Examining Authority's First Written Questions (ExQ1) Issued 17 December 2025

In response to the Examination Authority's first written questions issued on 17 December 2025, the MCA would like to comment as follows at Deadline 1, 9 January 2026.

Plate 2.1 Stakeholder areas of interest with regard to under-keel clearance

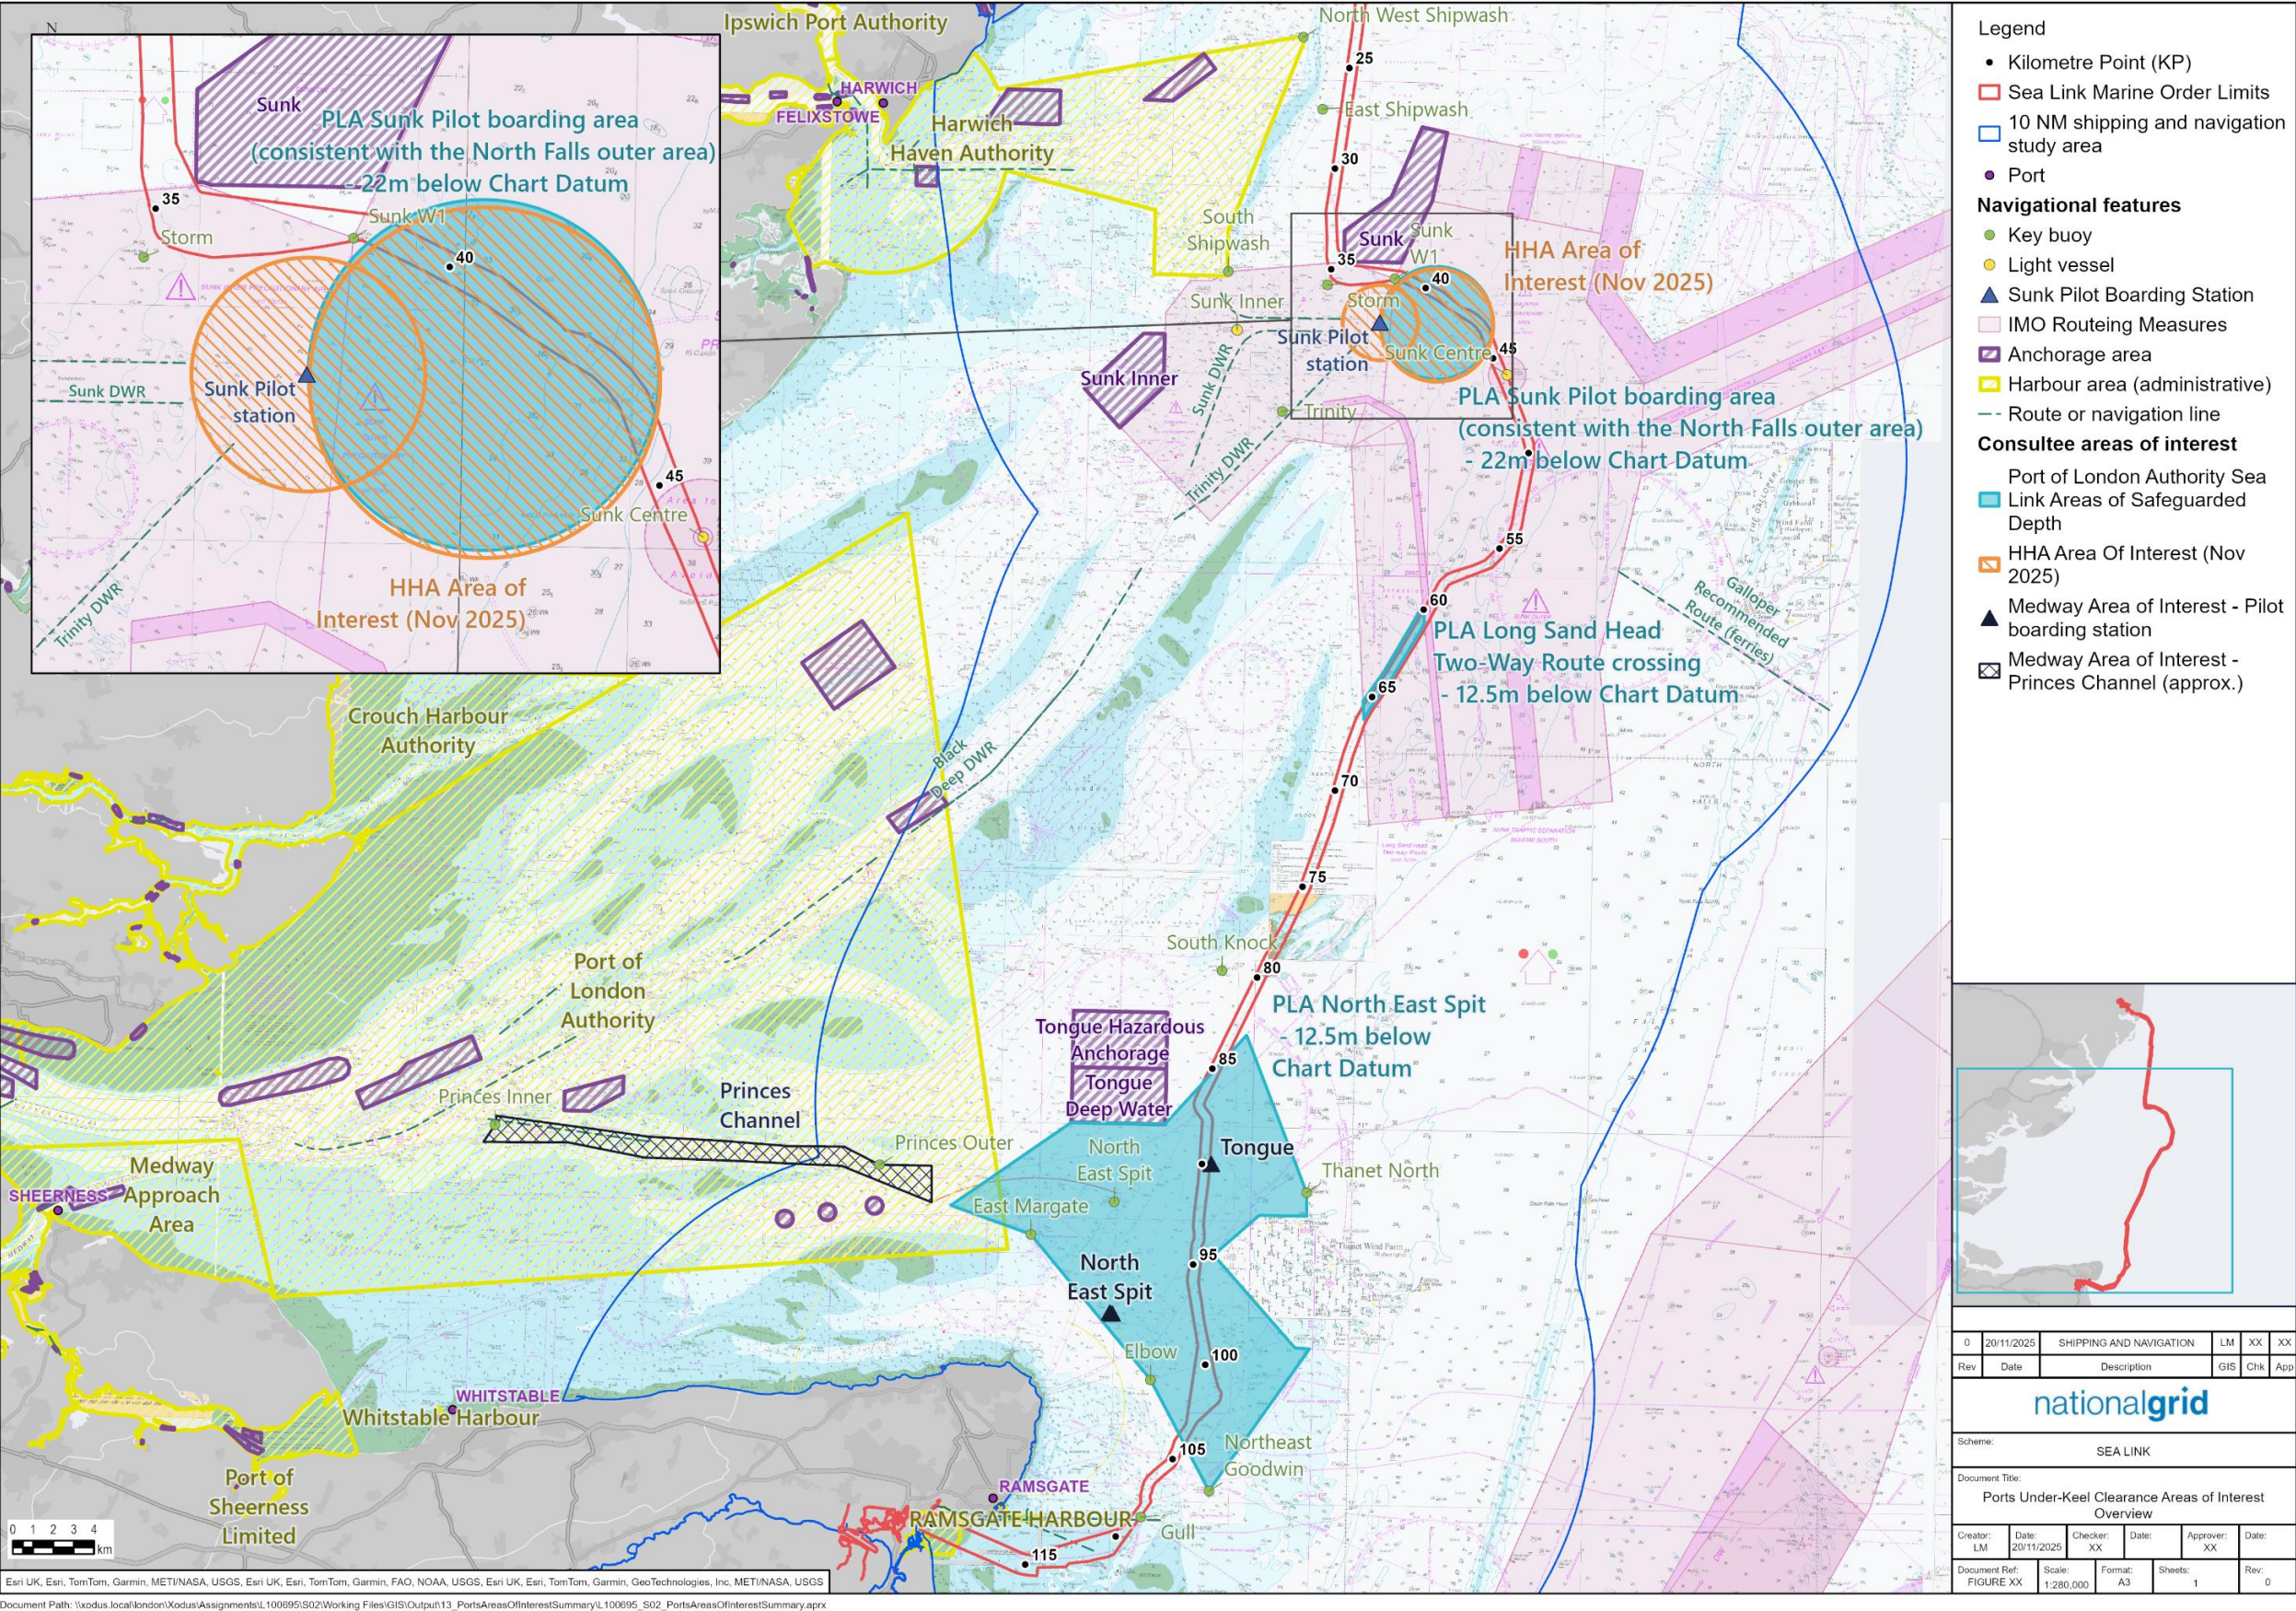
<p>Provide an update on reaching an agreement with the relevant stakeholders on safeguarding current and future navigable water depths. In responding, explain how DoL commitments can most effectively be secured in order to secure existing and reasonable future under keel clearance requirements. If this is to be through protective provisions, provide suggested wording for how this can be appropriately secured. Also explain any alterations or additions to the REAC, for example MPE02.</p>	<p>The MCAs' primary concern is to safeguard navigation safety for current and future vessel traffic, and this is of particular concern within the SUNK precautionary area at KP 33 to KP 45.</p> <p>The MCA requests that the applicant include a DCO-DML condition requiring the cable to be buried to a depth of at least 22 metres below chart datum. For the remaining sections of the cable route, the MCA is satisfied with the approach outlined in the Cable Burial Risk Assessment (PDA-039). If the applicant can commit to the Depth of Lowering (DoL) specified within the CBRA, the MCA considers that the risk to navigation safety will be reduced to As Low As Reasonably Practicable (ALARP).</p> <p>The applicant has committed to 12.5m depth below chart datum to be maintained within the Long Sand Head (LSH) two-way route and at the Northeast Spit which has been agreed with the ports for their purposes and the MCA fully supports. The MCA would also like a minimum of 12.5m depth to be maintained.</p> <p>In addition, from our data we can see vessels of more than 11m draught passing through the LSH in 2024 and considering the water depth available at this location (around 17-18m plus) the 12.5m allows the potential for a 6m plus reduction in navigable depth, which seems excessive considering there are no cable crossings here. Whilst the MCA supports the need for at least 12.5m, we believe the applicant can easily achieve more at this location. We would therefore like the applicant to ensure burial as identified within the CBRA and apply the 5% maximum depth reduction. This is also identified by the applicant in their CBRA. [PDA 039].</p> <p>The MCA will need more information and further consultation if there is <u>any</u> depth reduction <u>within KP45 to KP85</u>.</p>

<p>It should be noted that the LSH two-way route <u>may</u> be amended in the future because of the active migration of the sandbank. This may affect the existing navigation patterns in the SUNK region near the LSH. We would like to ensure minimal depth reduction to allow deeper draught vessels which may use this route in the future.</p> <p>At the NE Spit area, we can see numerous vessels of more than 11m using this area presently and vessels up to 14.7m have used this area in 2024. However, there are some locations where the water depth is less than 12.5m so the 5% reduction may not be appropriate across this area. Therefore, in discussion and agreement between MCA and the PLA, we would like to propose the following DCO DML condition wording to address this point:</p> <p><i>'For the defined Areas of Interest at the Long Sand Head and North Sea Spit, the works must not exceed a maximum 5% reduction in surrounding depth referenced to chart datum, unless otherwise agreed with the MMO in consultation with the MCA and relevant ports. Any changes to surrounding water depth must not reduce water depth to less than 12.5m'.</i></p> <p>To confirm, the MCA and the PLA are fully aligned and in agreement that the MCA requirement of no more than 5% reduction would apply where the depths are greater.</p> <p>Any depth reduction in the area should be minimal and cable burial needs to be ensured as per the CBRA.</p> <p>Where existing cable crossings are necessary, we would expect the applicant to not exceed the 5% maximum depth reduction at any of the cables crossing within the NE spit. If this cannot be achieved, they must consult the MCA as soon as possible to confirm that the risk to navigation safety is ALARP.</p>

<p>For any future planned cable crossing, the project should discuss with those owner/operators to determine how best to achieve minimum depth reductions.</p> <p>The MCA has provided the applicant an outline of our Areas of Interest for further discussion as we are responsible for the SUNK VTS and the safety of navigation outside port limits. These Areas of Interest will be updated with the exact locations from the shapefiles for the KPs along the cable route (recently provided by the applicant), and will be discussed further with the applicant on 16th January.</p> <p>The MCA's Area of Interest have expanded from the applicants' original proposals because for example (but not limited to):</p> <ol style="list-style-type: none"> 1) the pilot boarding station is not a specific location point (or definable by coordinates) it is an 'area' and we need to accommodate that 'area'; and 2) These Areas of Interest only apply when there is simultaneous operations with North Falls and Five Estuaries, and when there is restricted visibility. If no concurrent activity is happening and visibility is good this area of interest for these restrictions would not apply. <p>As MCA has previously explained that the SUNK area is very busy with converging marine traffic with many vessels, including some of the largest in the world. The SUNK region is highly constrained with dense maritime traffic, challenging environmental conditions, specialist pilot boarding arrangements, and the presence of deep-draught vessels potentially up to 20m draught in the future. The risks of collision or running aground here could have catastrophic consequences.</p>

**Plate 4.1 Overview of the water depths within the Area of Interest and the Sunk wider area. Extract of Figure 10:31 from the Integrated Geophysical and Geotechnical Survey Report (NEXT GEO 2025)**

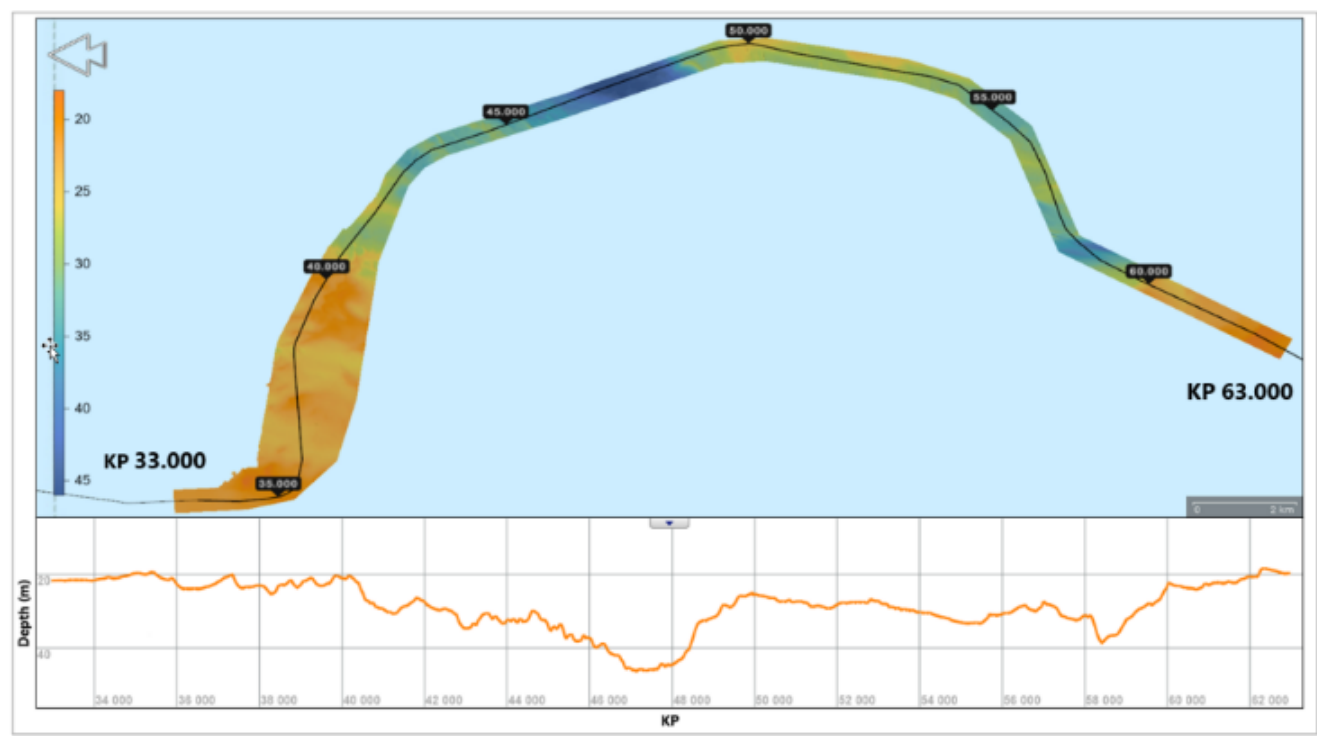
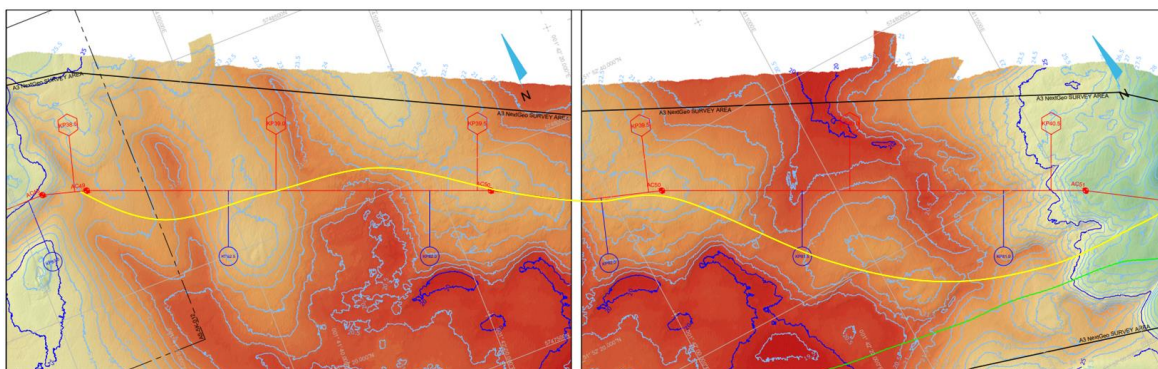
QISN7	Relevant stakeholders including	Cable burial risk assessment (CBRA)	The SUNK area represents the primary pinch point along the cable route due to its relatively shallow water depth combined with the deep draughts of vessels operating there (see Fig.

<p>London Gateway Port Ltd (LGP), Maritime and Coastguard Agency (MCA), Port of London Authority (PLA), Harwich Haven Authority (HHA)</p>	<p>Provide comments on the submitted CBRA [PDA-039].</p>	<p>6.4.4.7.A.15 of APP-284). In contrast, areas such as North Shipwash (between KP15 and KP20) experience high concentrations of vessels crossing the proposed cable route (see Fig. 6.4.4.7.A.11 of APP-284), but the charted depth is approximately 20 m, and most vessels have a maximum draught of less than 10 m. Consequently, this area is currently considered less critical.</p> <p>The SUNK area of concern extends from KP30 to KP70, where there is a high concentration of commercial traffic, including ultra-large vessels operating mainly within restricted depths; particularly between KP30 and KP40 (as noted in APP-284). From KP40 to approximately KP60–65, water depths are generally greater than 20 m. Provided the applicant achieves cable burial as outlined in Table 24 of the draft Cable Burial Risk Assessment (PDA-039), we would consider this section acceptable. We would expect the project to bury the cable to 22m below Chart Datum from KP33-45 as explained previously.</p> <p>Between KP60 and KP65, most vessels have draughts of 10–15 m (see Fig. 6.4.4.7.A.15 of APP-284). The minimum depth along the cable route in this section is 17.8 m. If the draft CBRA is complied with, we believe the risk of reduced under-keel clearance can be minimised. From KP85 to KP95, most vessels again fall within the 10–15 m draught range, with the minimum depth along the route being a 14 m patch, which vessels generally avoid. The next minimum depth is 17.6 m, and the draft CBRA specifies cable burial to 2.5 m below the seabed in this area, which we consider acceptable.</p> <p>Between KP95 and KP105, west of the Thanet Offshore Wind Farm, lies another chokepoint identified in our written and relevant representations. This area sees vessels with draughts of 10–15 m and occasional transits of vessels exceeding 15 m (see APP-284, Fig. 6.4.4.7.A.15). The draft CBRA proposes</p>

<p>burial to 0.5 m below the seabed here; however, we request the applicant to consider deeper burial, as they have identified the presence of deep-draught vessels operating in this area. We expect the project to avoid any further reduction in navigable depth in this area.</p> <p>Finally, west of Goodwin Knoll and approaching Pegwell Bay, water depths are often below 10 m. However, as vessels operating here are of shallow draught, we consider this a lower risk, provided the cable is buried and does not reduce navigable depth.</p> <p>In summary, the minimum depth the cable route passes through within the SUNK Inner Precautionary (within KP33-45) Area is 17.9m, which is West of the SUNK Deep-Water Anchorage. There is a 16.4m depth patch just outside the cable route between the Storm buoy and the SUNK W1 buoy.</p> <p>Where burial depths as informed by the Cable Burial Risk Assessment (CBRA) cannot be achieved in the maintained depth channels, any potential reduction in surrounding depths referenced to Chart Datum will need special attention and further consultation with the MCA, Ports in the area and other relevant stakeholders. Any consented cable protection works must ensure existing and future safe navigation is not compromised.</p>
